CITY OF MERCER ISLAND

RE: Request for Information #2 for File No. SUB21-006, CAO21-004, SEP21-022 – Milestone Short Subdivision
7621 SE 22nd ST, Mercer Island, WA 98040; King County Tax Parcel # 531510-1846

Re: Rand-Milestone Short Plat
7621 SE 22nd Street
Mercer Island, Washington
CAO 21-004

MILESTONE PRELIMINARY SHORT PLAT

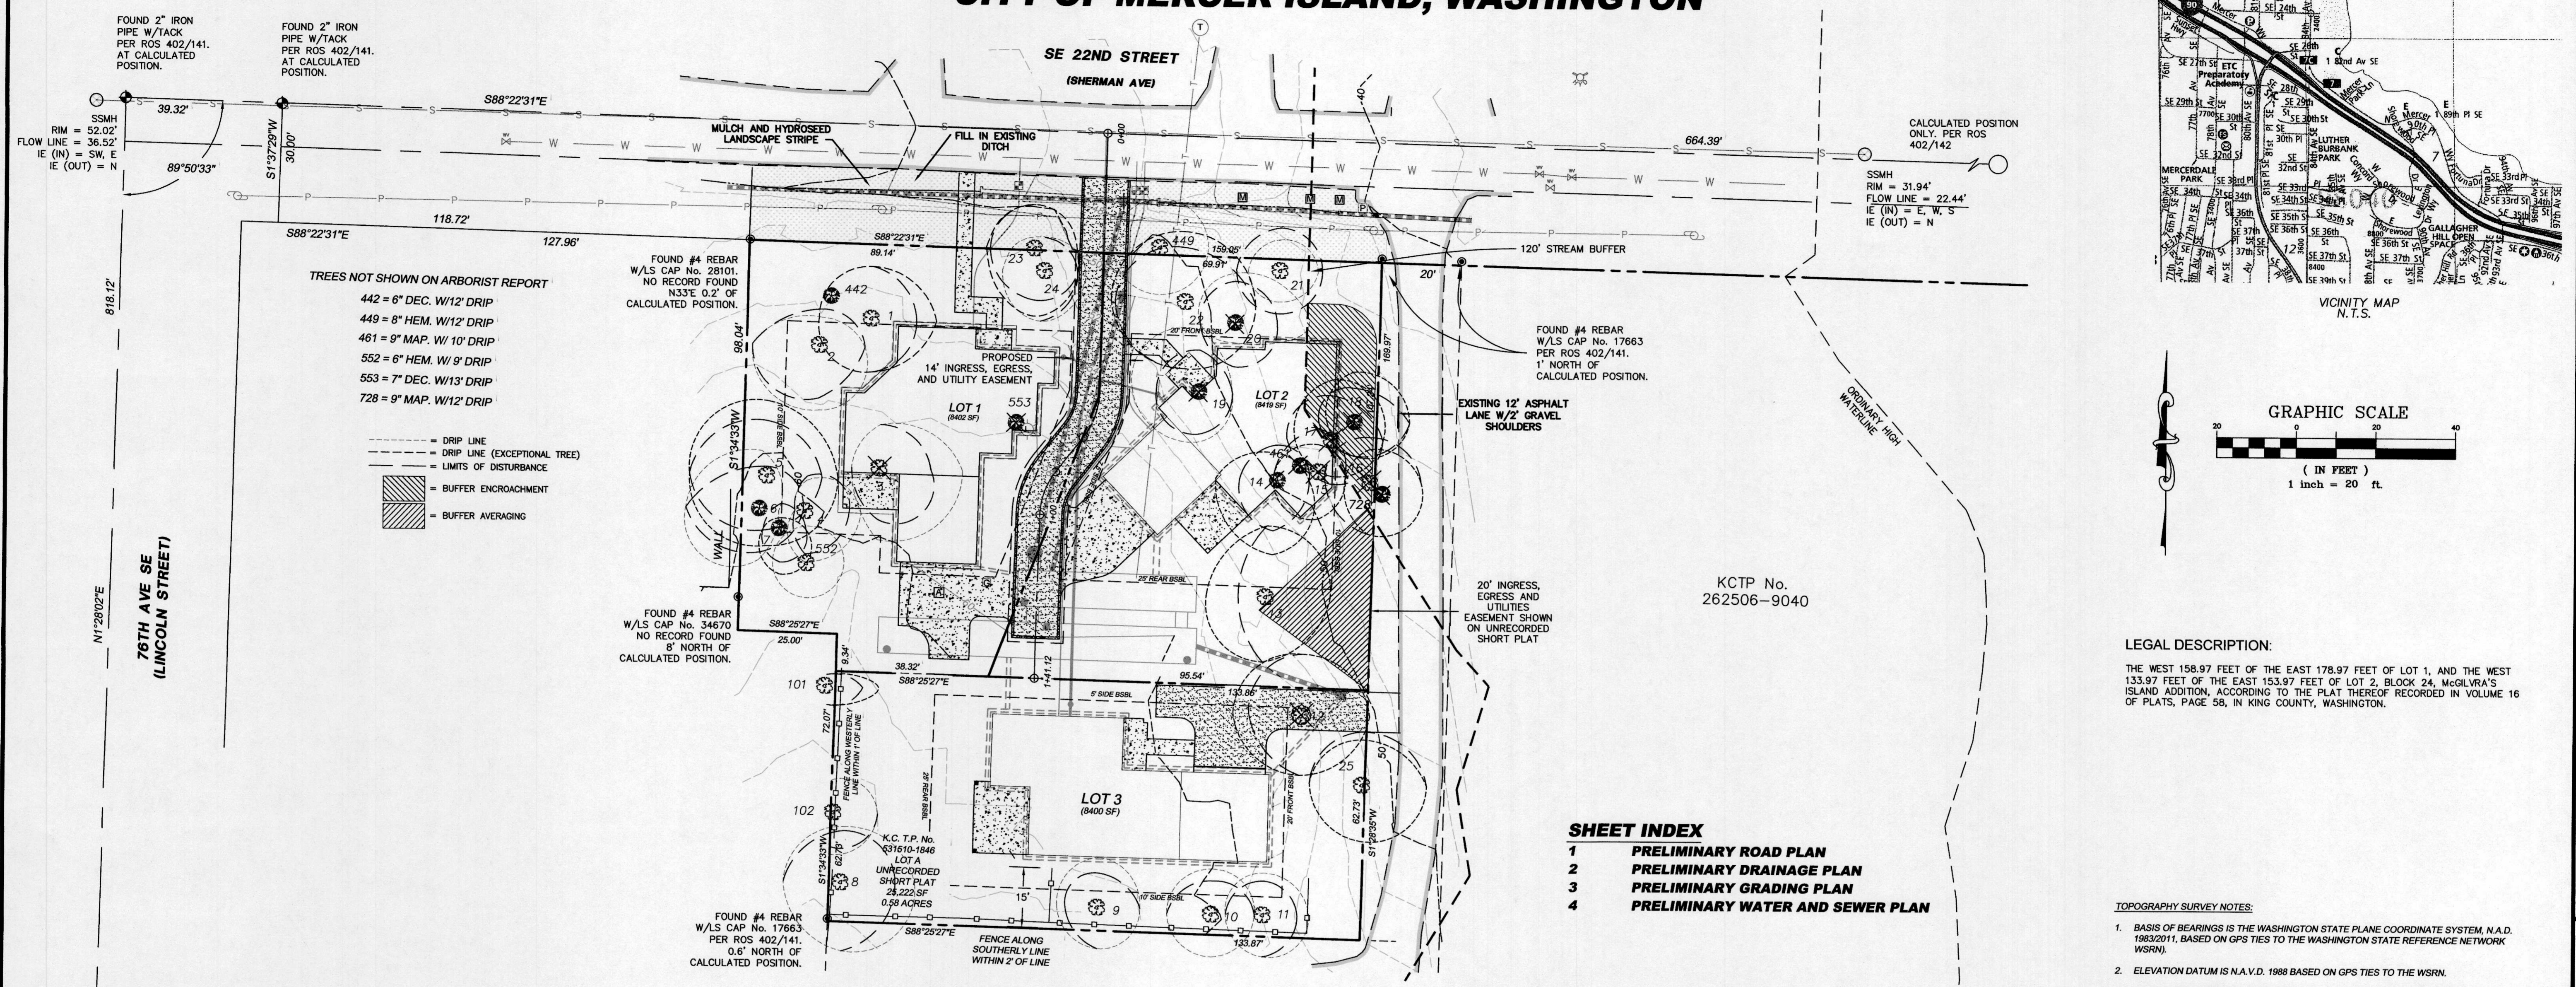
It appears that Lot 2 is located over the sloped portion (also designated landslide hazard) of the site. No final grading is provided in this area.

Comment 4: This code section (MICC 19.09.090) cannot be met without meeting code section MICC19.07.160. Provide proposed final grades for the proposed lots. Provide information regarding proposed building excavation, e.g., will basement levels be involved? Provide an anticipated basement level elevation or finished floor elevations for at-grade structures for the proposed lots.

Adequate grading information should be provided for Lot 2 so that the geotechnical engineer can assess potential slope stability impacts and provide design mitigation recommendations.

# RAND-MILESTONE 3 LOT PRELIMINARY SHORT PLAT

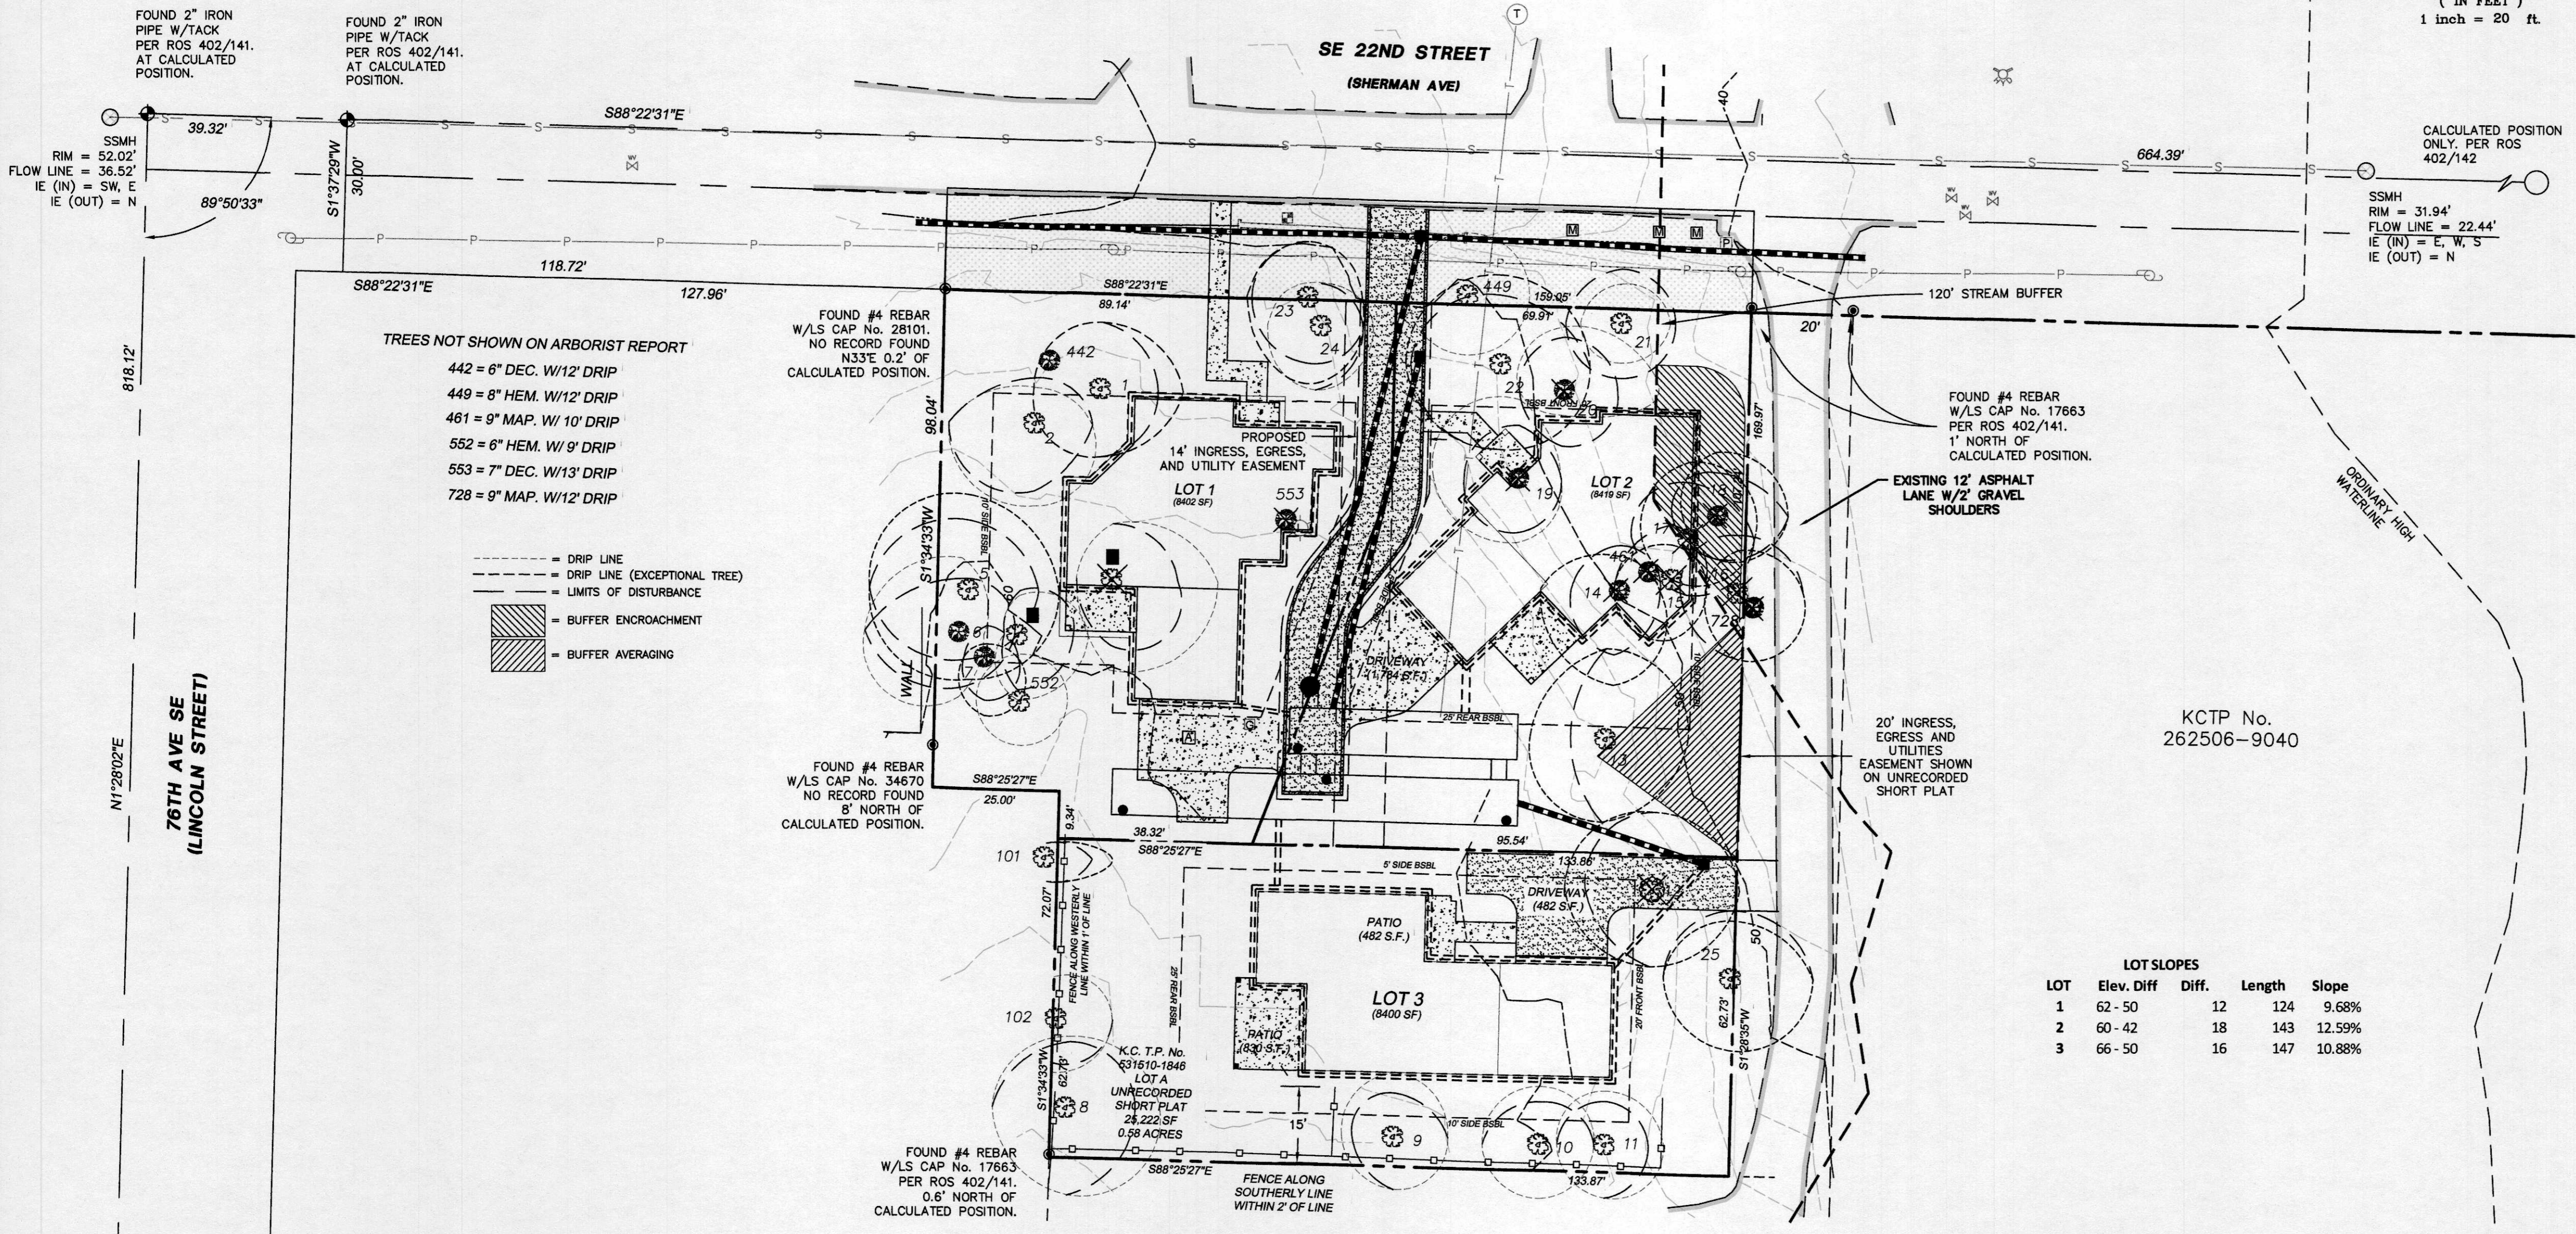
1. Please show the new lot lines with distances and bearings, as well as legal descriptions for all proposed easements and new parcels.
